**RE: Evans Park PRD, 17909 25<sup>th</sup> Ave NE  
1<sup>st</sup> technical review comment response letter  
Permit #: PA22-003**

Please refer to our responses below which address all review comments received from you via email on April 11, 2022. You will find the markup comments listed in the order that they were written followed by our response in *italics*.

HUSEBY HOMES  
**EVANS PARK**  
PRELIMINARY ROAD AND UTILITY PROFILES AND SECTIONS

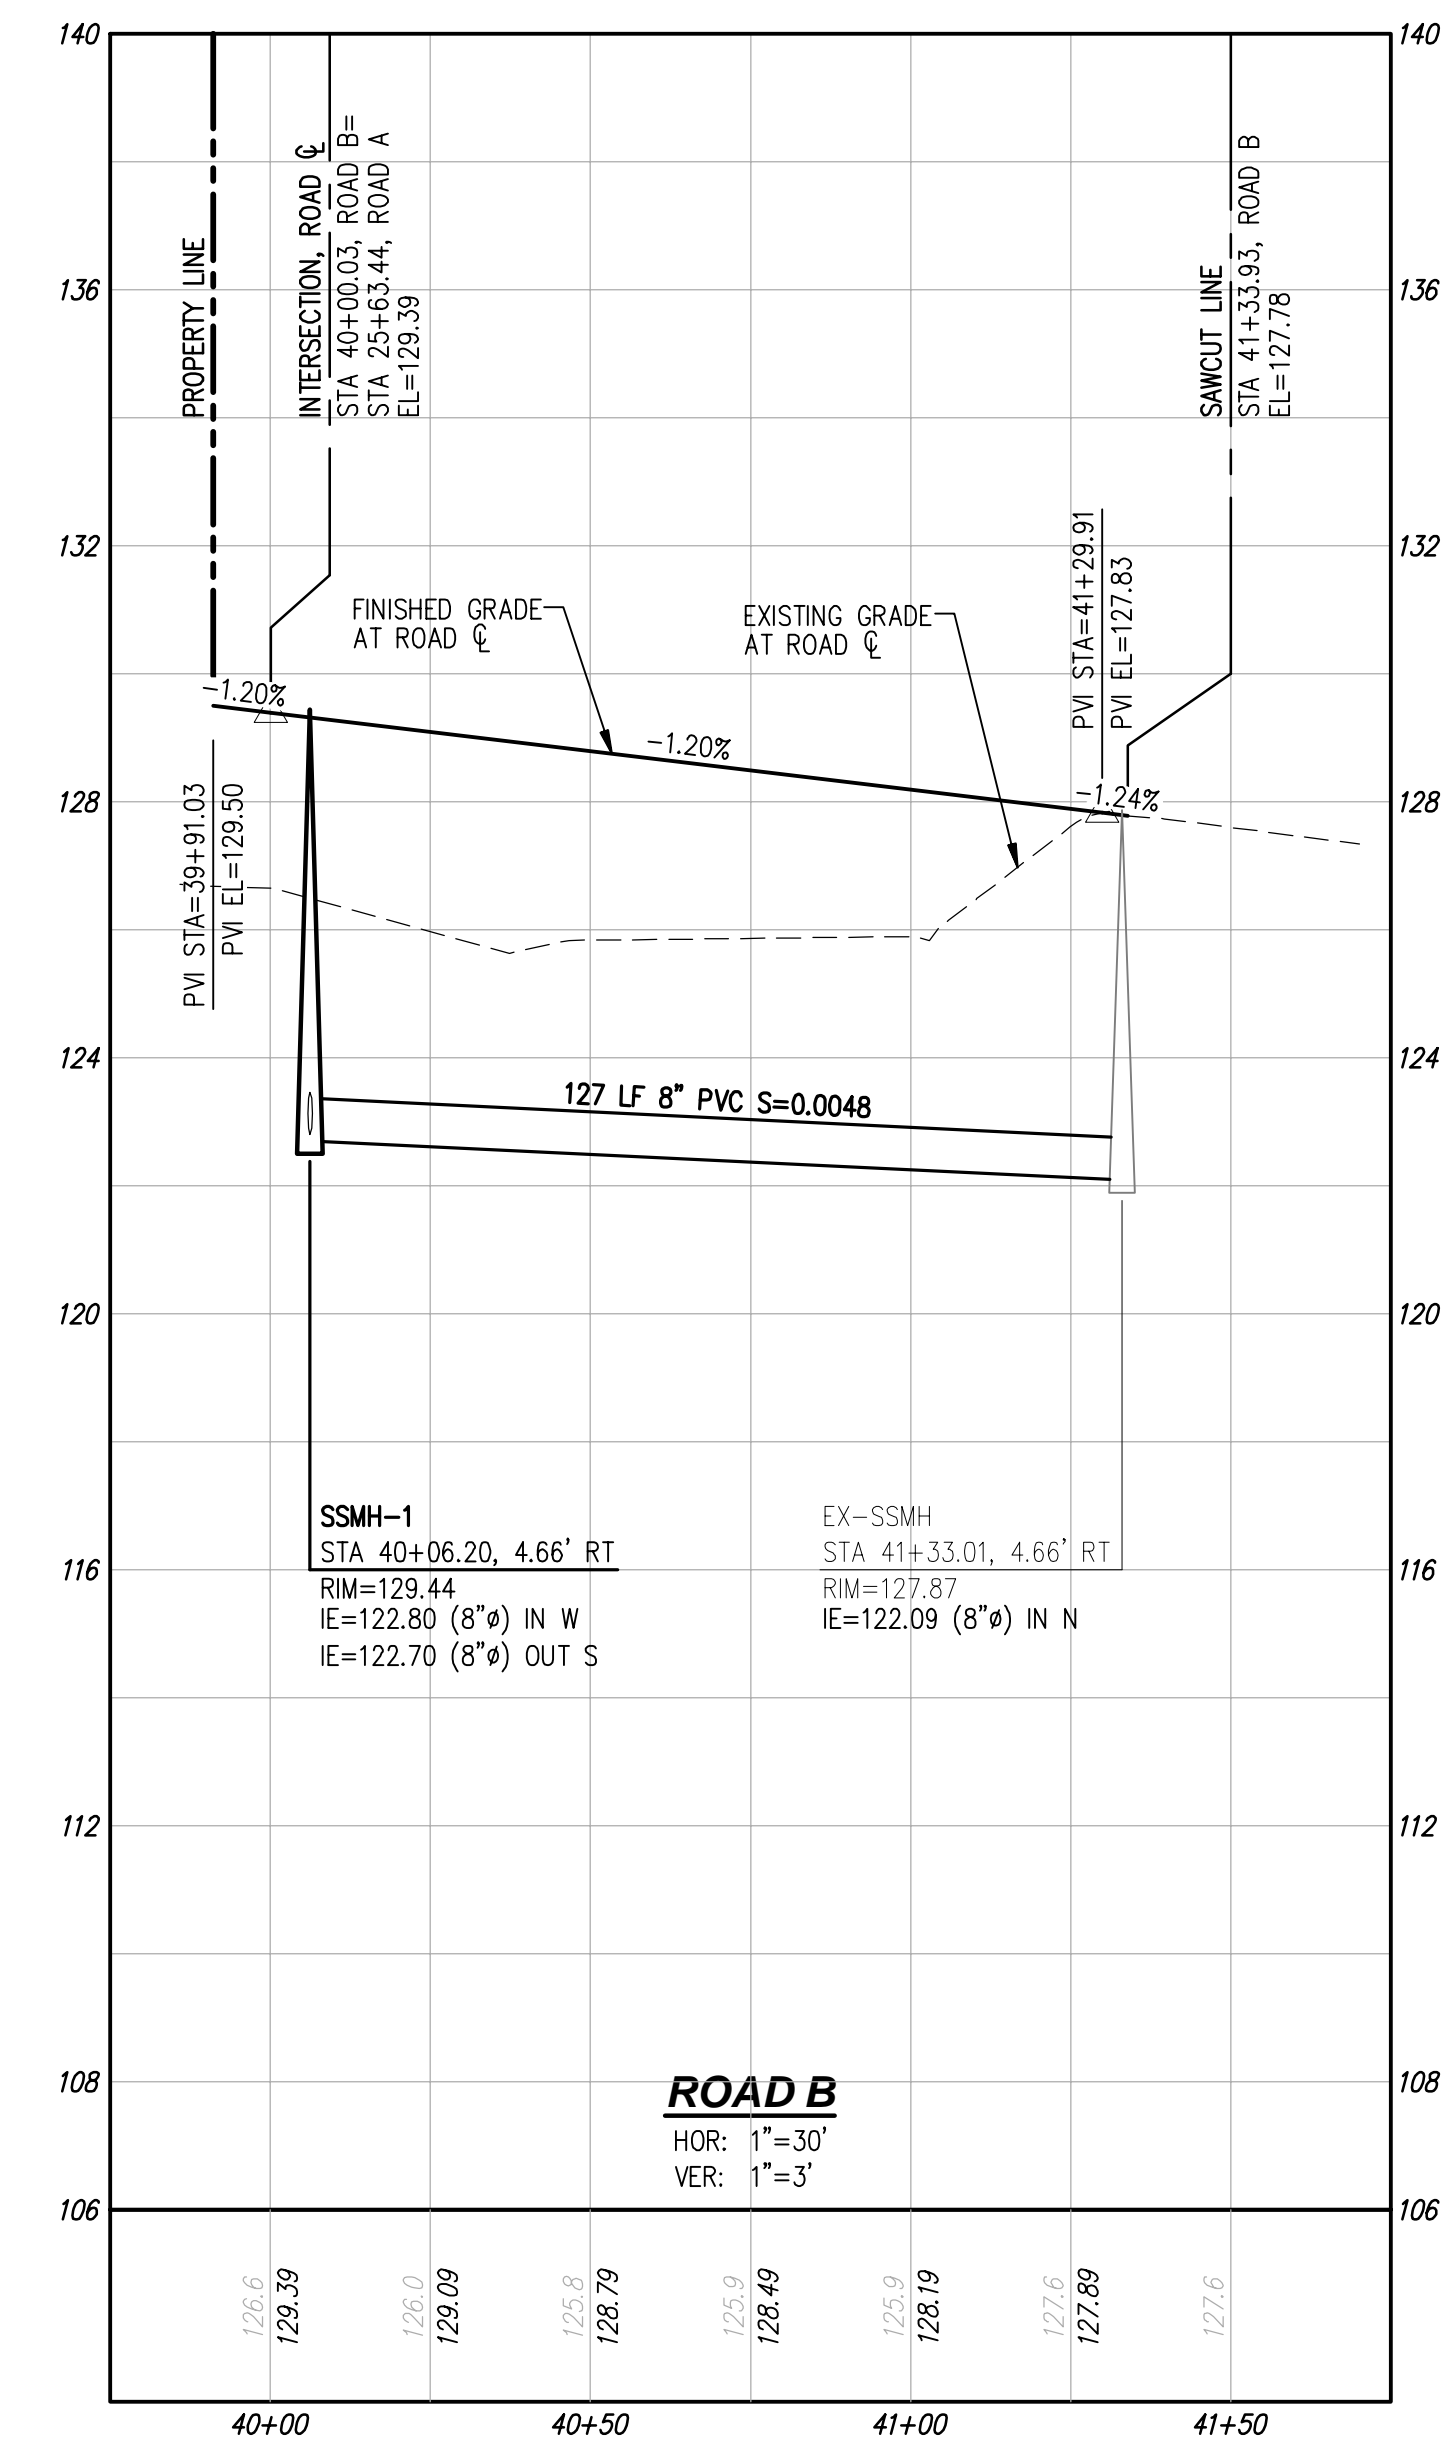
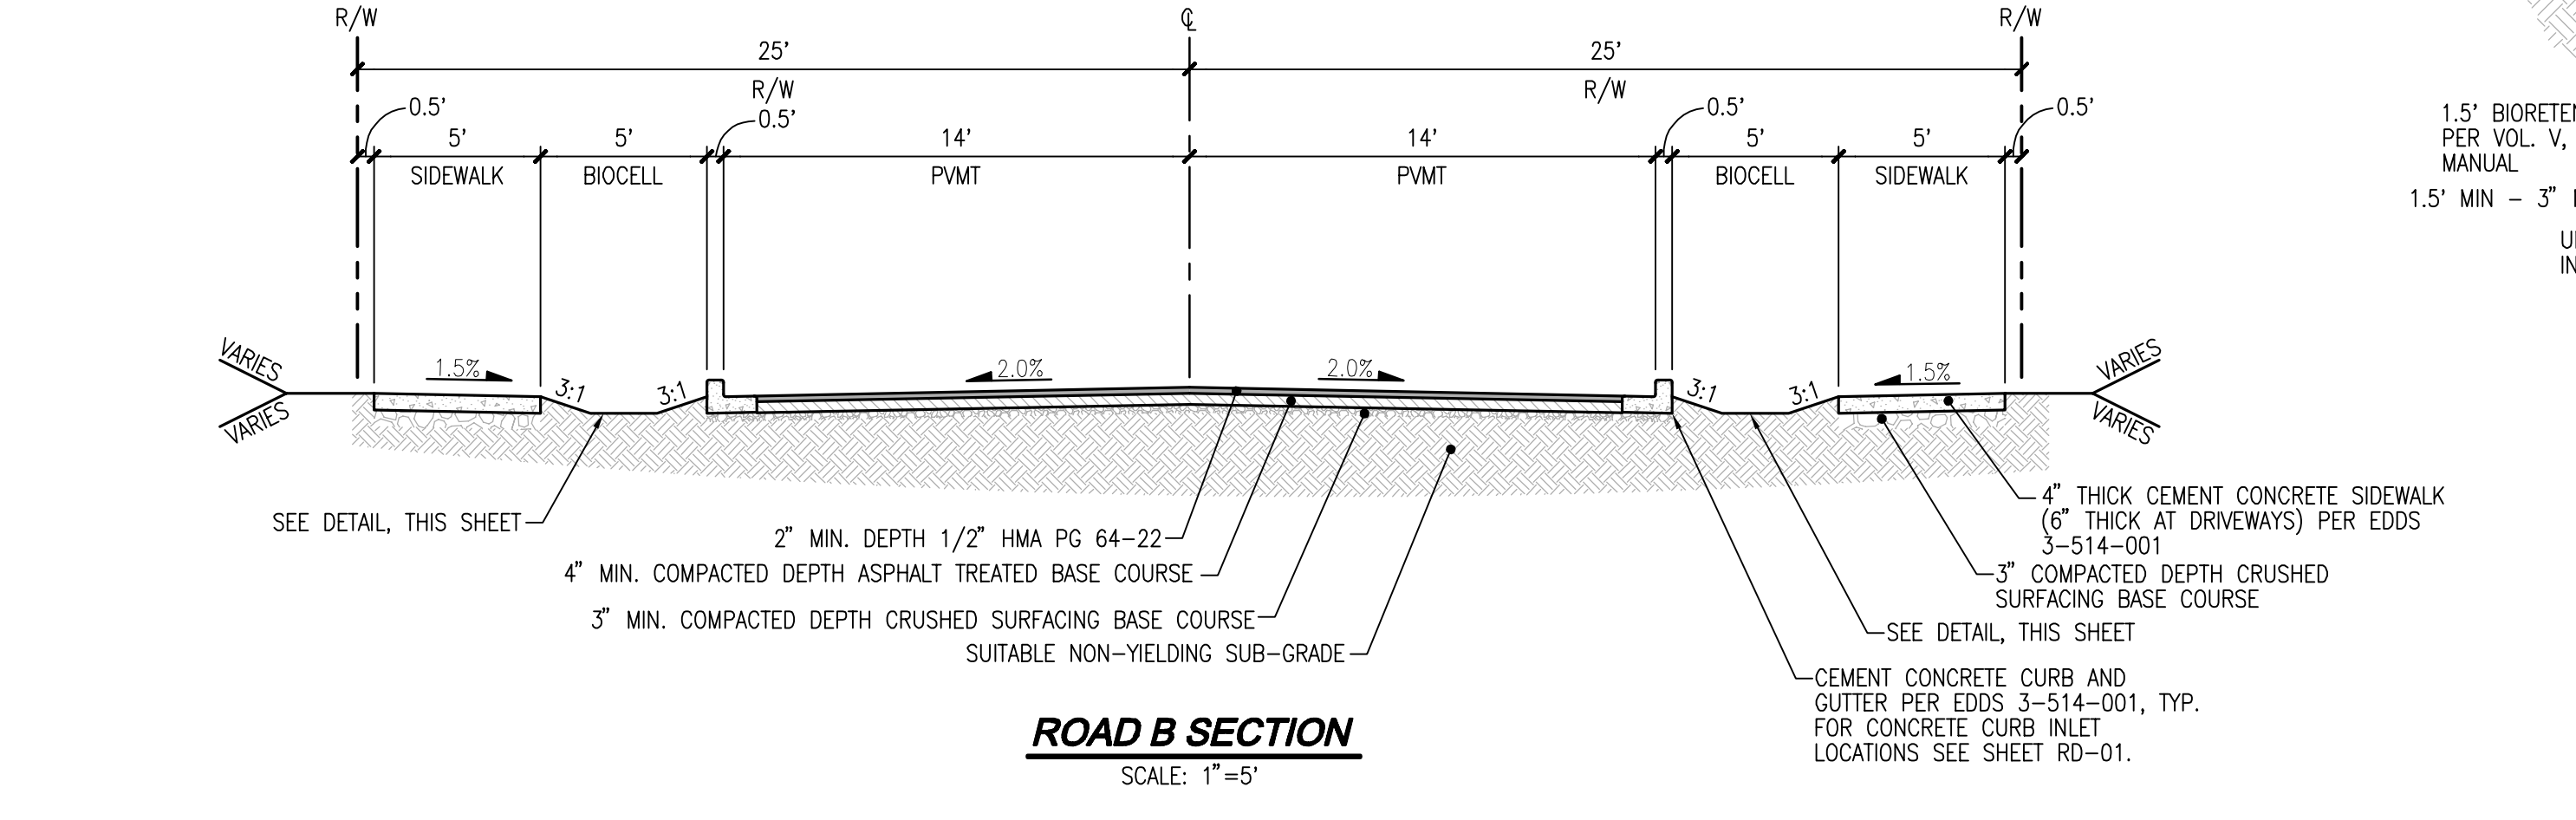
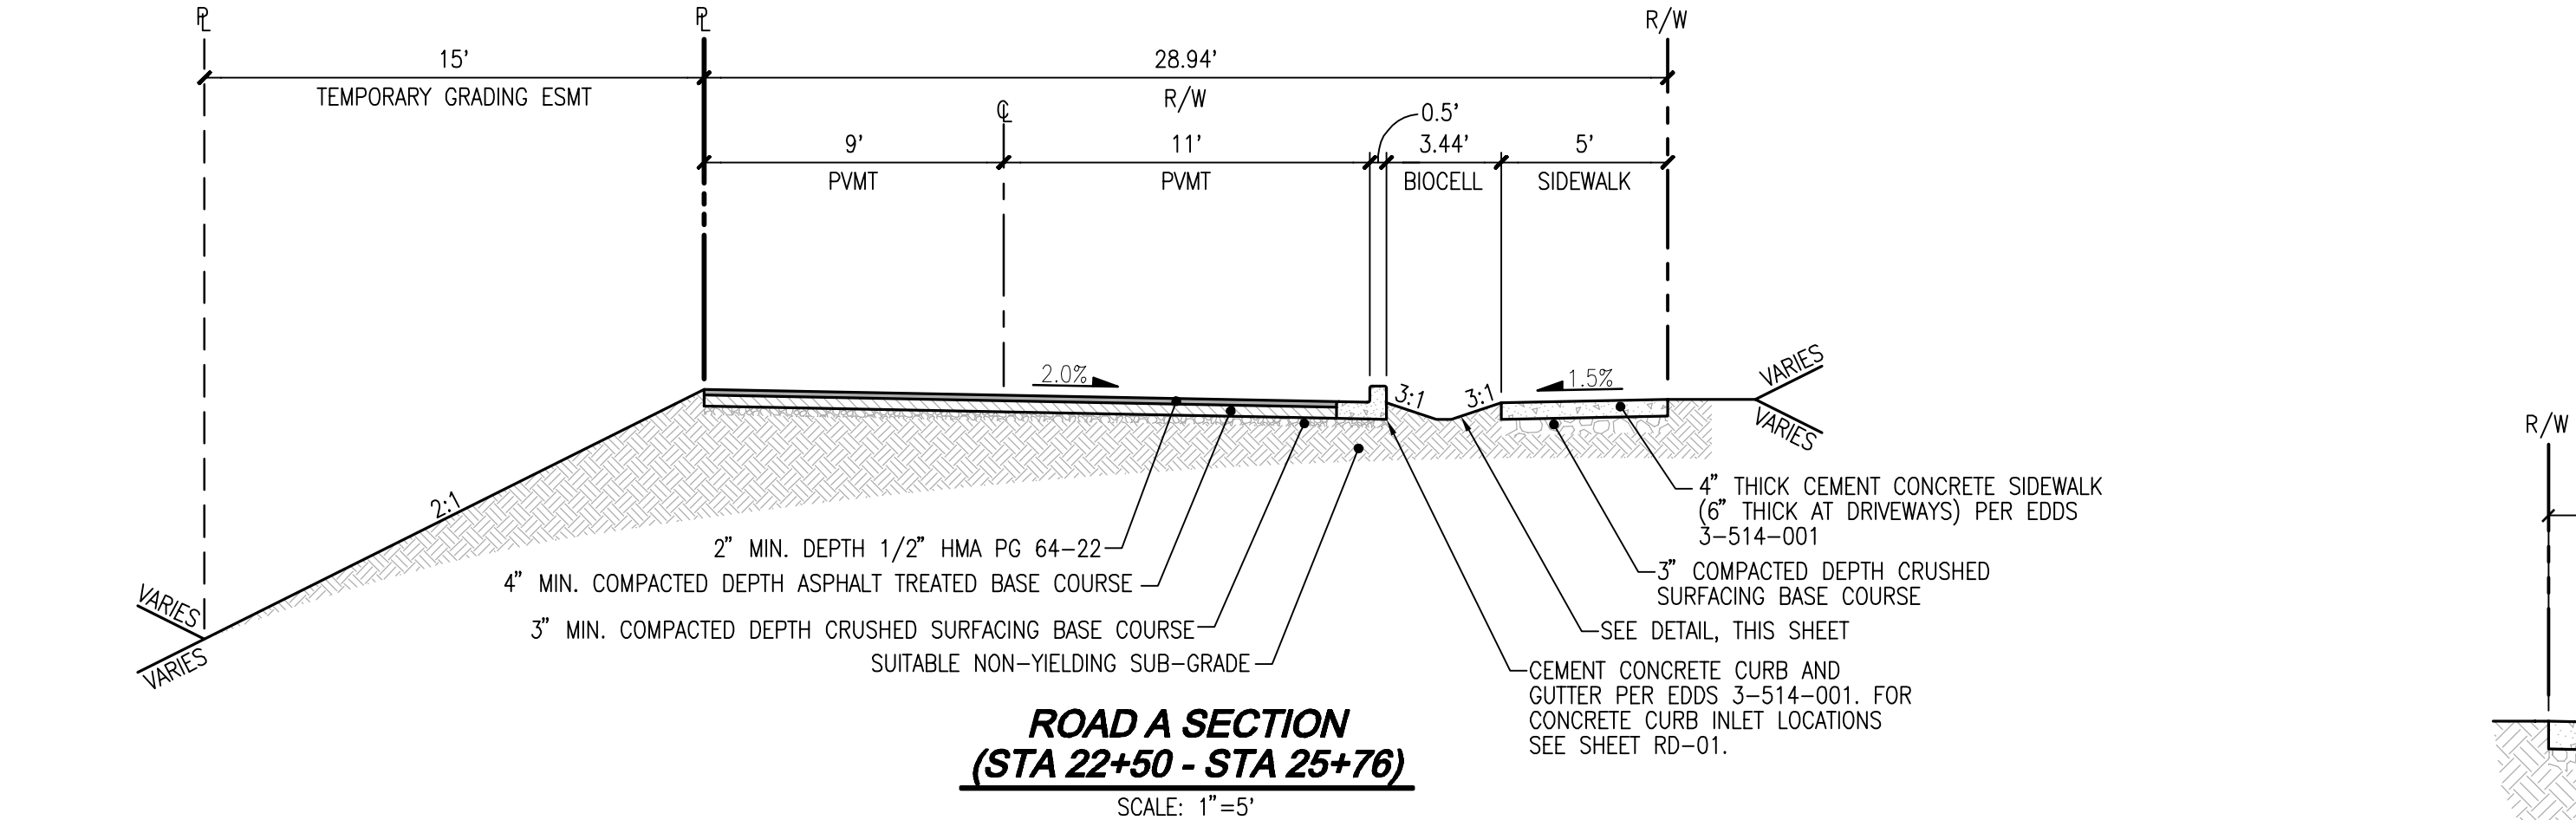
- a. It doesn't appear that a variance was submitted for the planter strip along Road A, regardless a full 5' planter along the entire street will be required

**Response: The Road A section has been revised to show a 5' planter and ROW**

***dedication and lot depth have been adjusted accordingly.***
